From: Sue Howell
Sent: 07 November 2018 15:30
To: Planning.Responses
Cc: Anita Gardner
Subject: RE: Planning Consultation on M/94/18/DOC

Comment from Greenspace

APPLICATION M/94/18/DOC
NO:

Description of Works: Application for approval of matters reserved by condition imposed under M/39/17/HH relating to condition No.4 (Landscaping) & 6 (Drainage)

Date May 2018	Approved by
Drawn by Mark Tuson	Scale - 1:50
Notes	
Client Mr S Gore	Site Middleton House Yapton Road Middleton on Sea PO22 6DU
MT Planning & design For all your planning needs	
07950 887579 mtplanning@hotmail.co.uk	
REVISION:- A	DRAWING NO:- MT / 1547 / 1

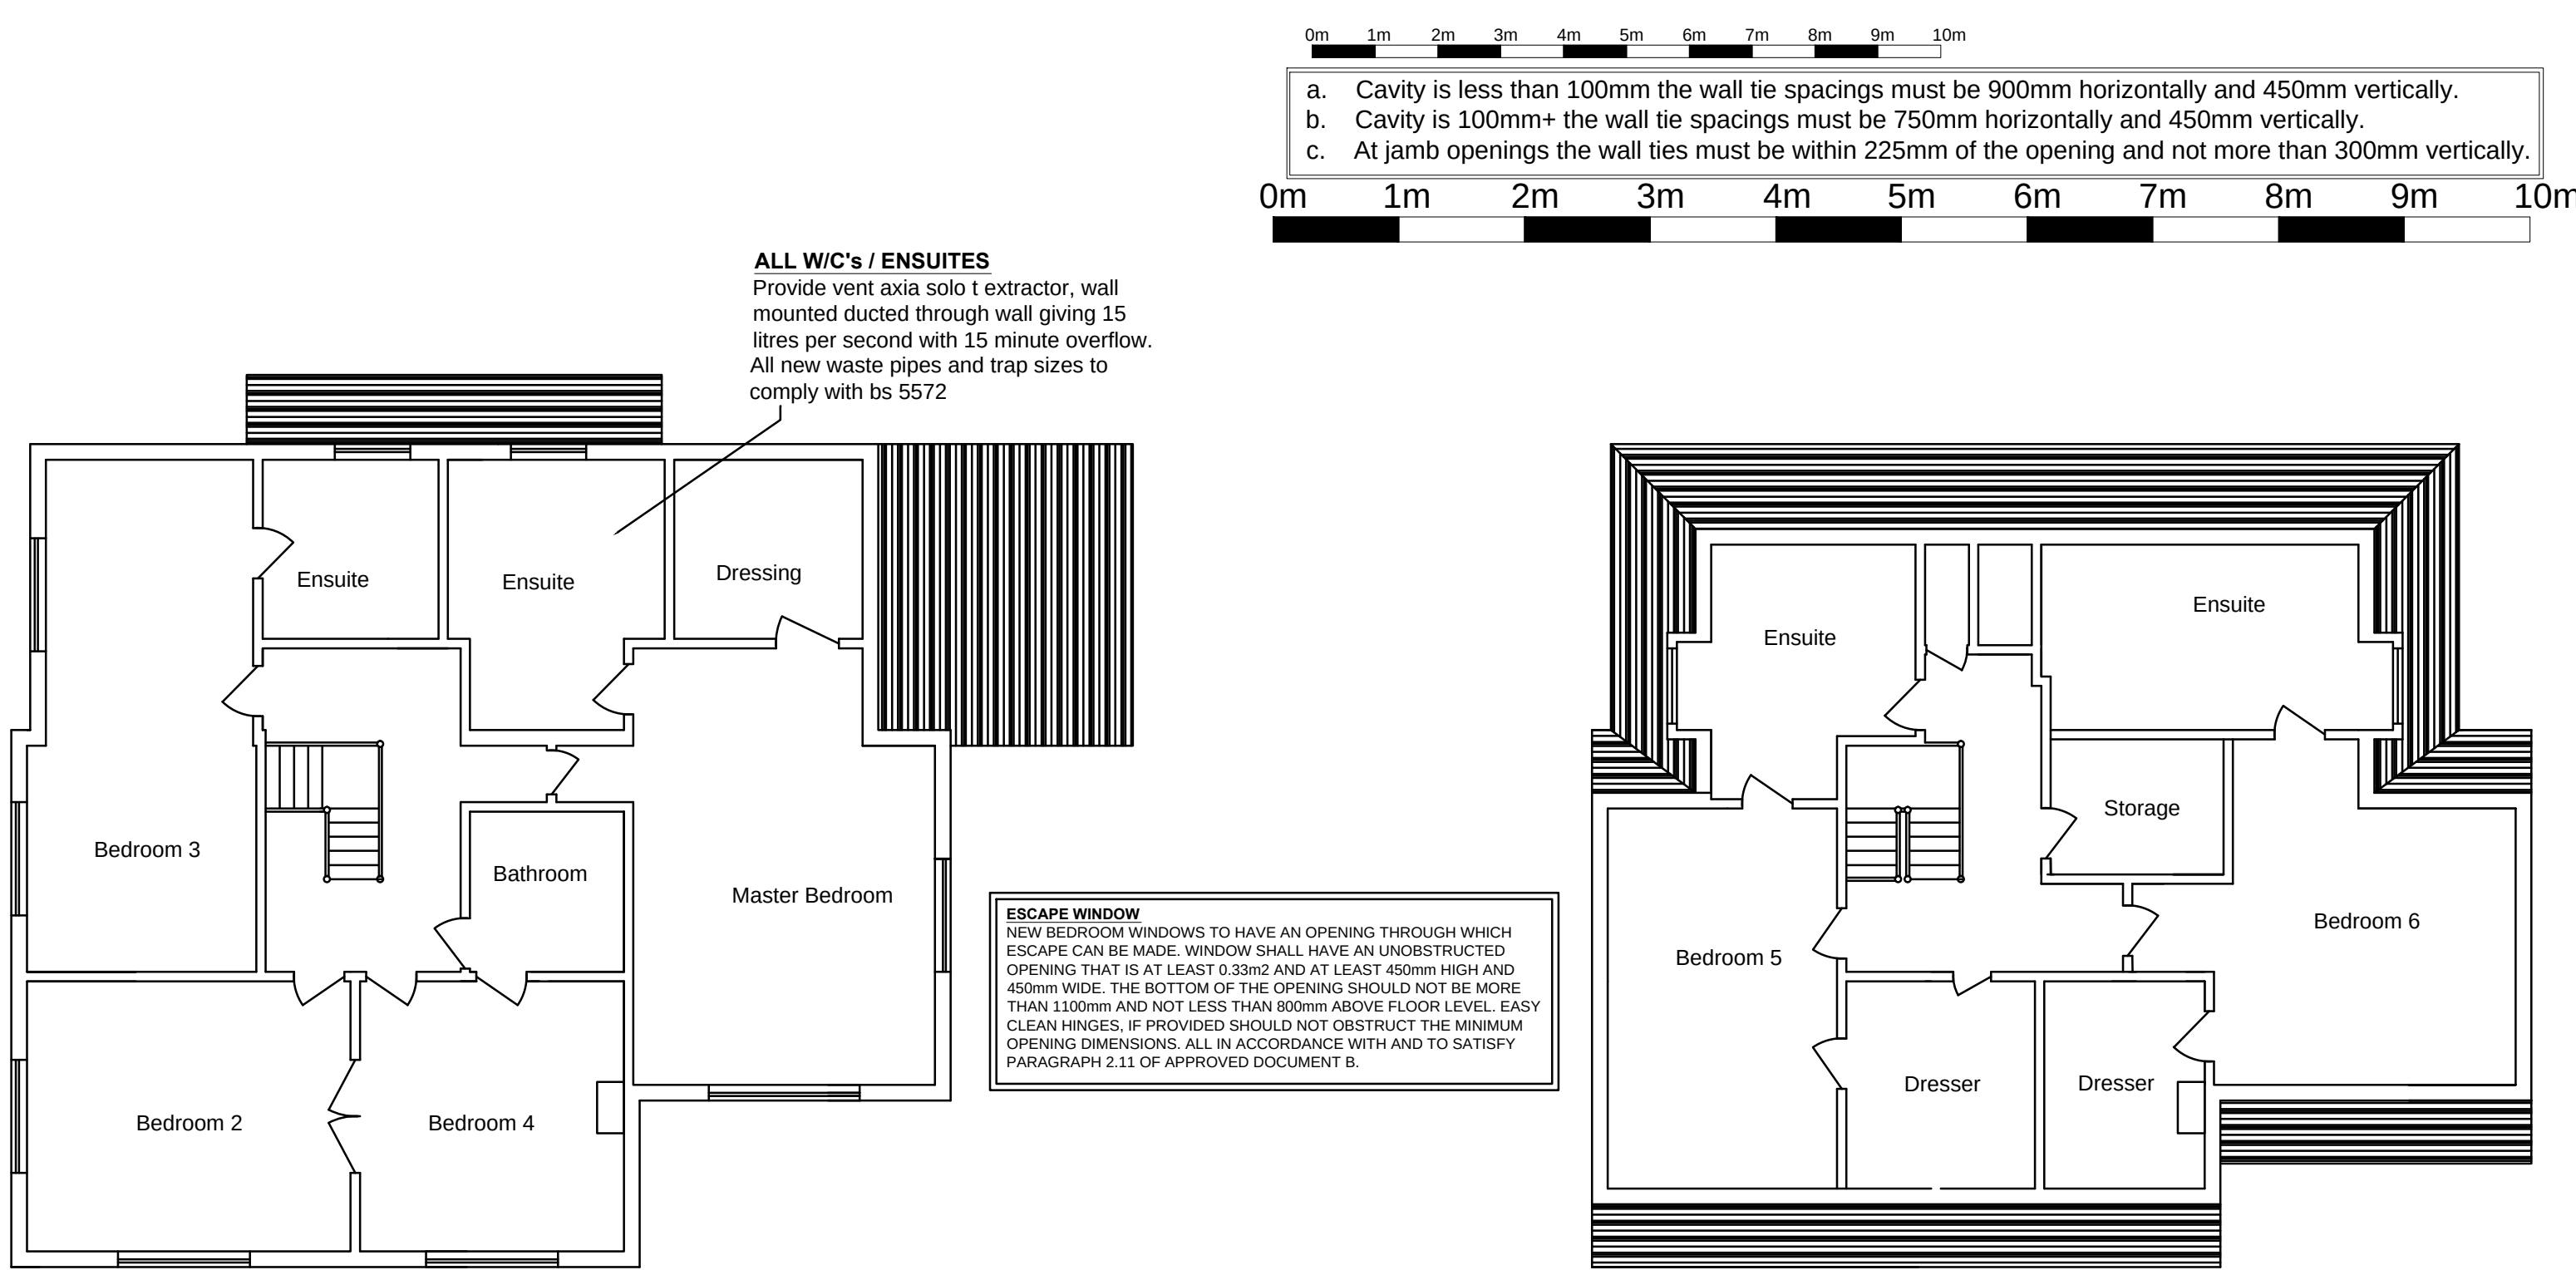
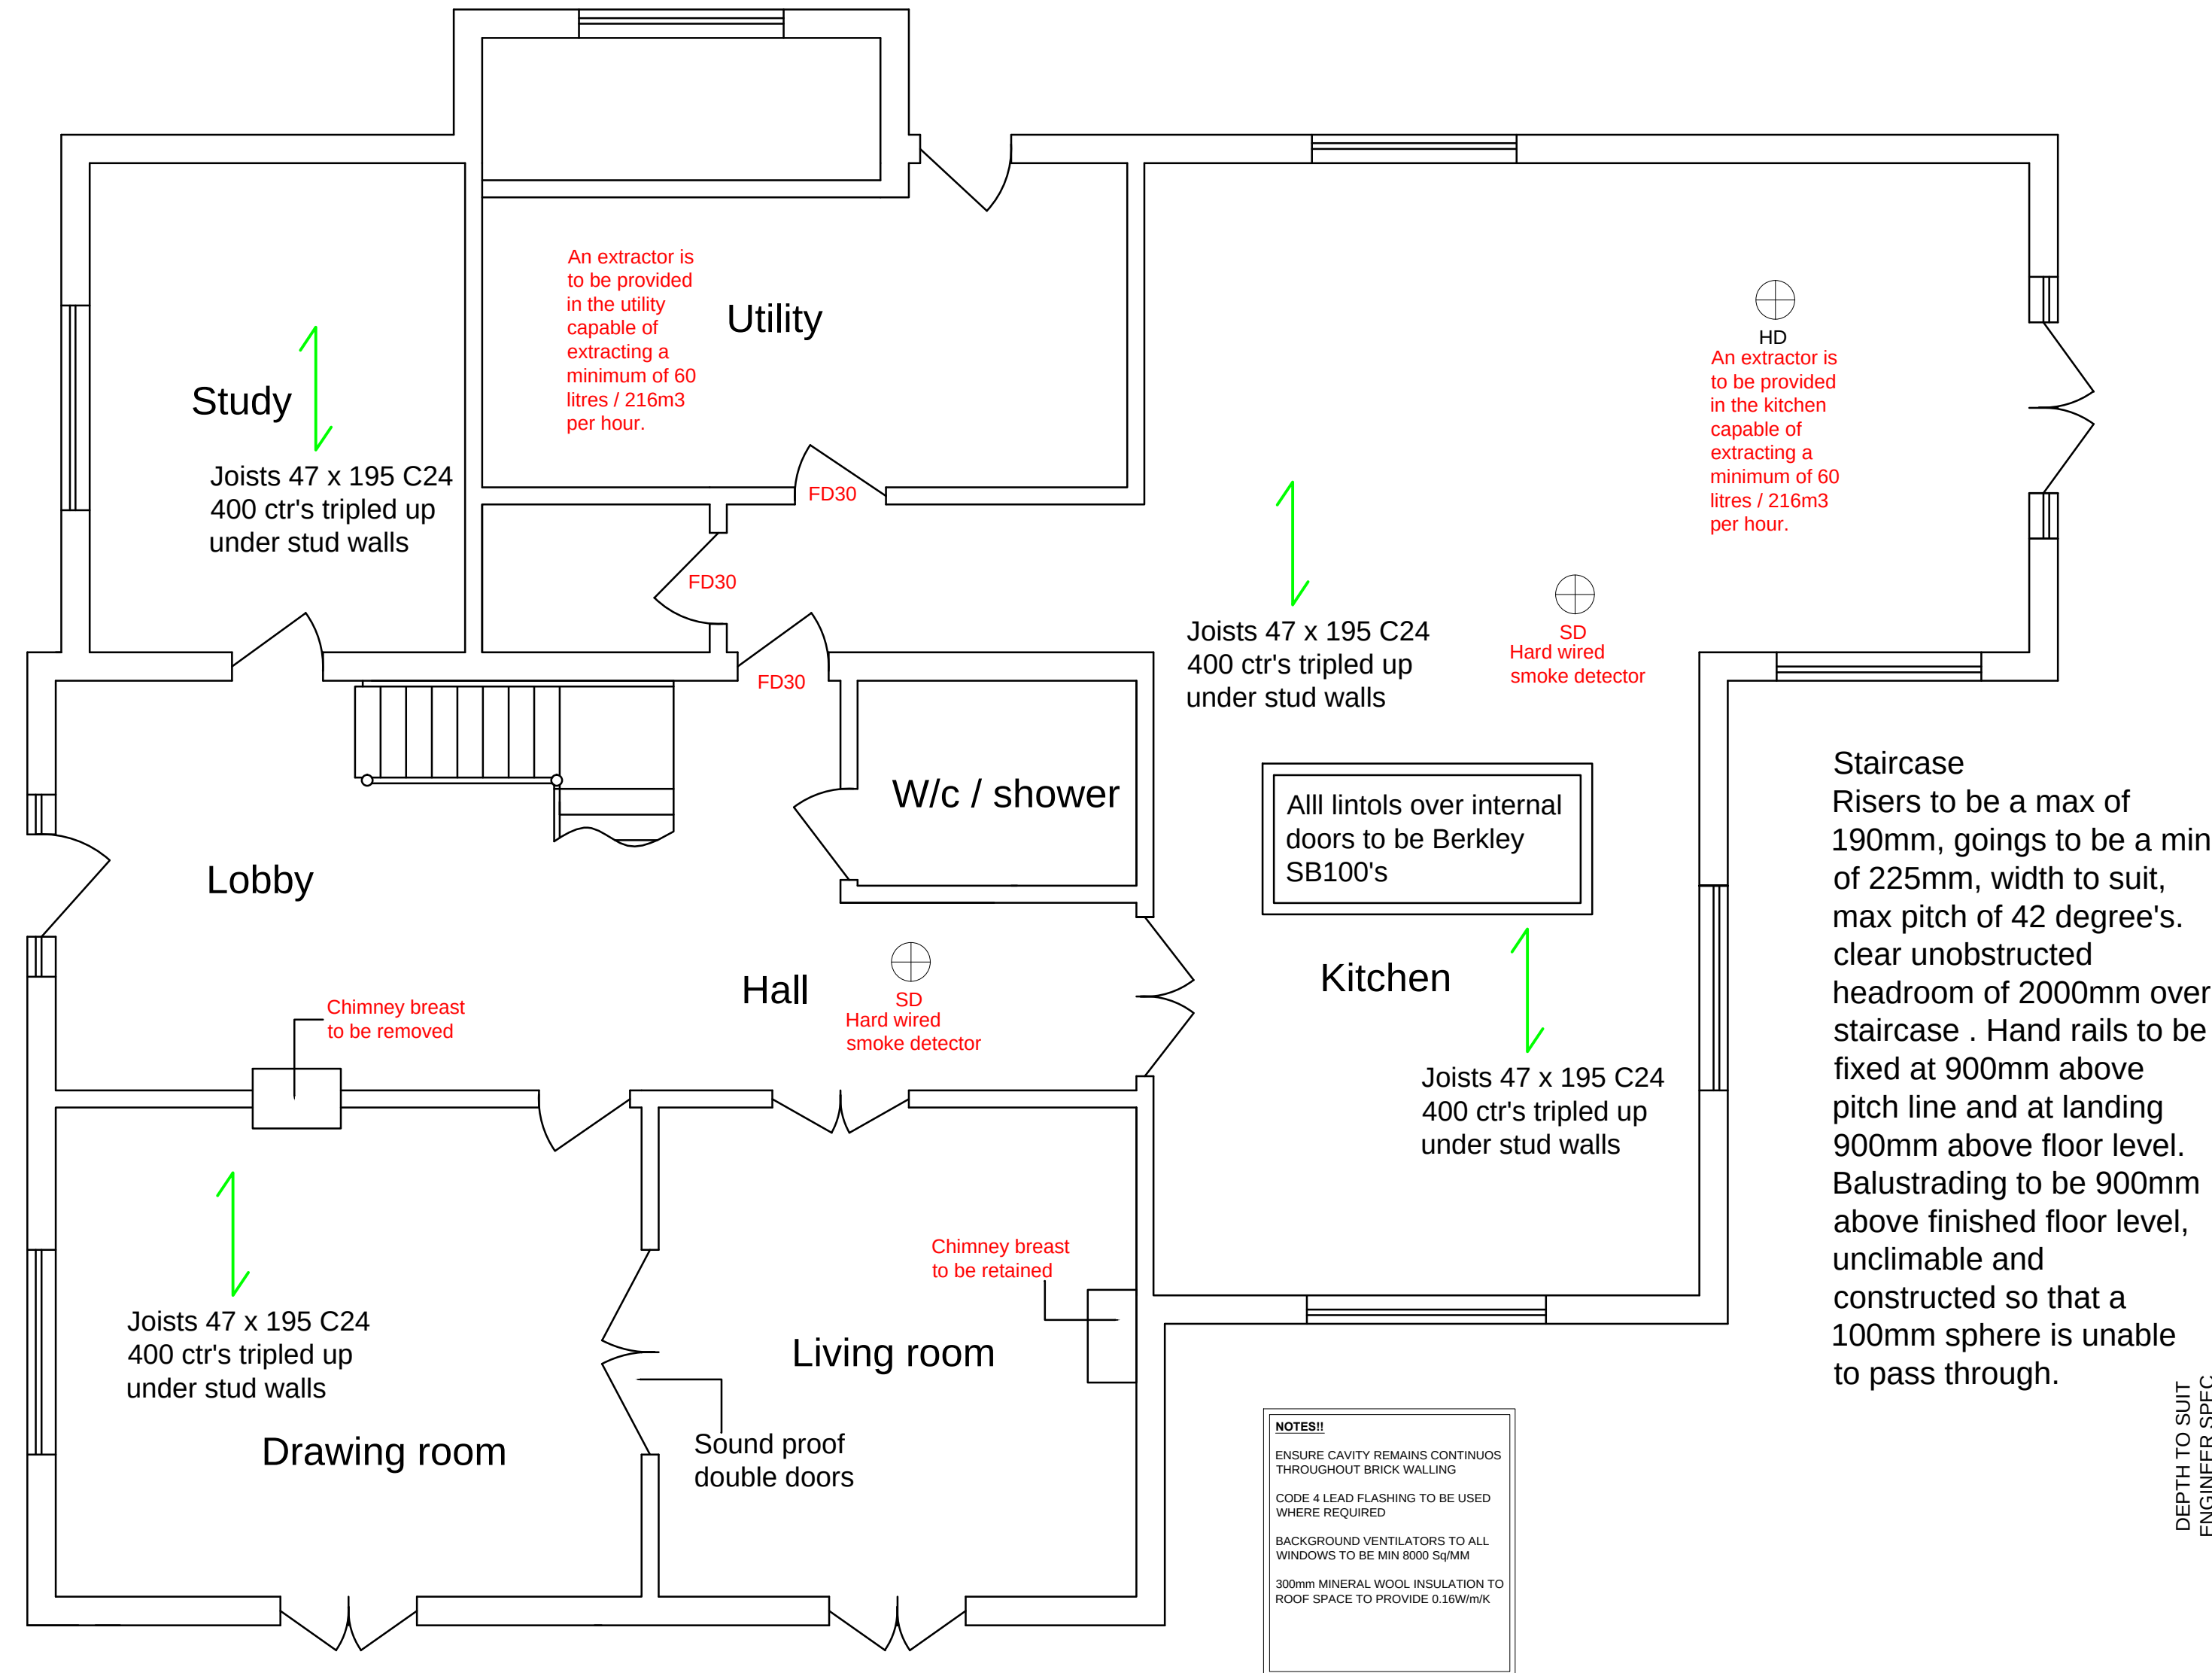
Further to submission of Dwg MT-1547/1 Rev A, I would recommend that there is insufficient detail provided re proposed landscape scheme detailing species choice, specific numbers, planting densities and size at time of planting and also lacking information re tree protection measures therefore **I would not recommend the discharge of Condition 4 landscaping** on application M/94/18/DOC imposed under M/39/17/HH until the above information has been submitted for approval.
